DECISION DELEGATED TO HEAD OF PLANNING

Application No: H11-1055-23 **Applicant:** Mr & Mrs K Kearns
Proposal: Extension & Alterations
Location: 17 Windsor Gardens Long Sutton Spalding
Terminal Date: 2nd February 2024

ShadowCast Drawings 17 Windsor Gardens

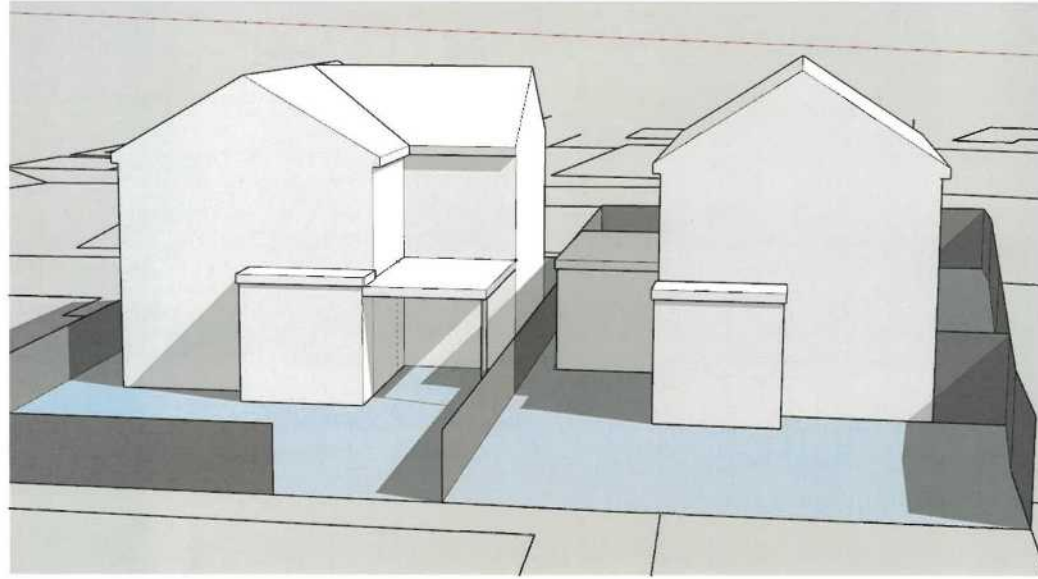
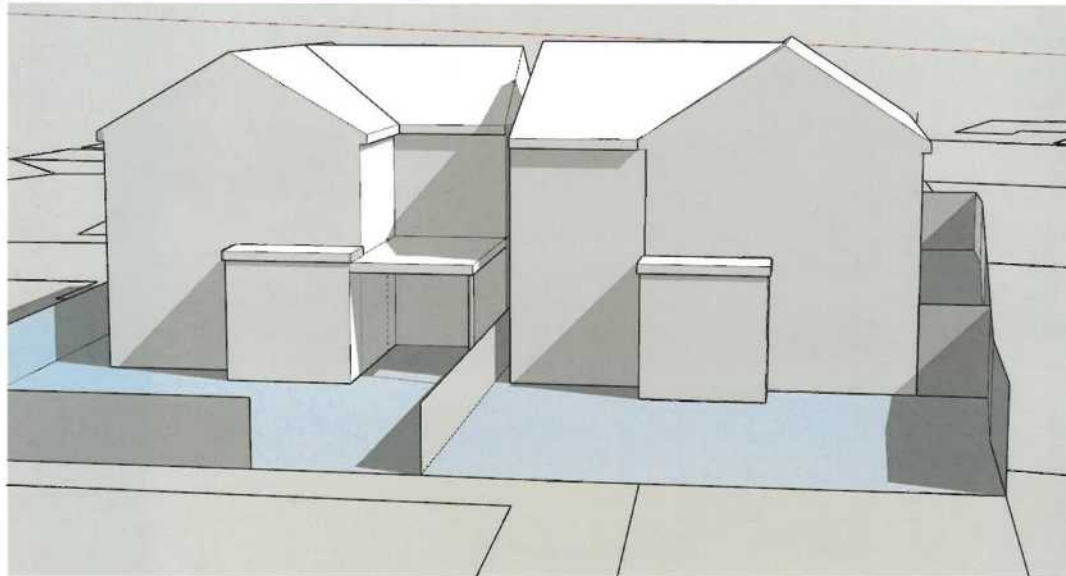
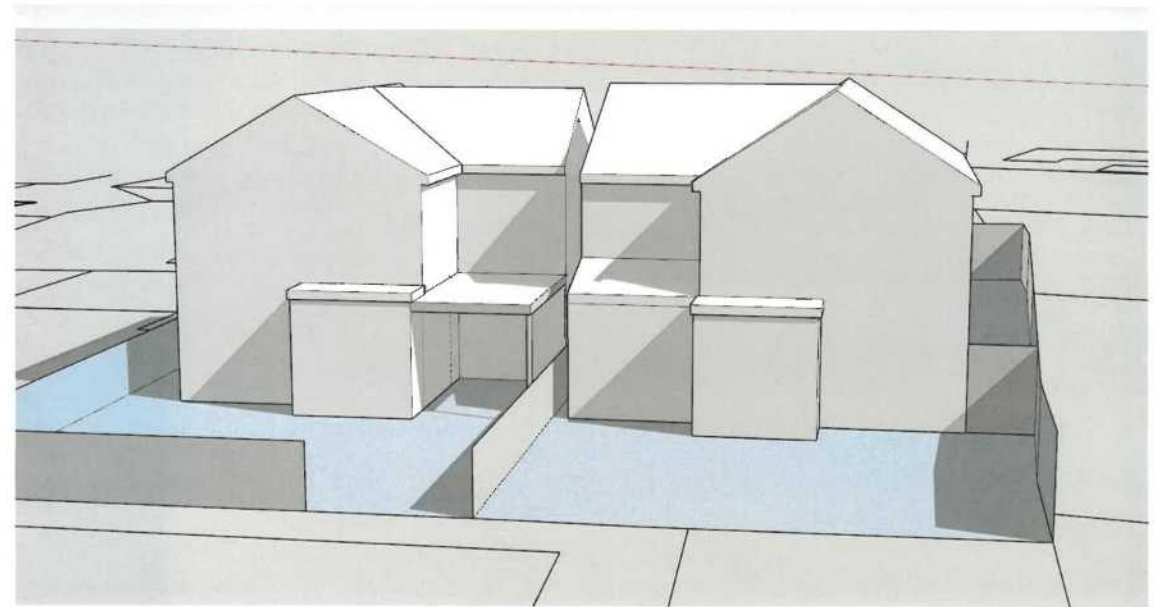
Shadow Cast Drawings have been submitted alongside this application due to concerns that overshadowing would arise following this extension being carried out. These drawings clearly outlined that a significant and material increase in loss of light would occur on the neighbouring property particularly due to them having a window located on the front with the drawings showing how as existing there is no shadow where as the proposed drawings block the majority of light from entering this room. An amendment was requested to combat this issue, however this was not submitted and therefore the proposal is not acceptable in this regard. Therefore, due to the proposed extension being sited level to the front elevation this causes a significant and material increase in overshadowing and should be refused.

As detailed above, there are no concerns surrounding overlooking however due to the scale and design of the proposal it is considered to be such that there would be significant and unacceptable impact on the residential amenities of the occupiers of adjacent properties or land users due to a drastic increase in overshadowing. As such, the proposal is considered to conflict with the provisions of the Section 12 of the National Planning Policy Framework (December 2023), and Policies 2 and 3 of the Local Plan.
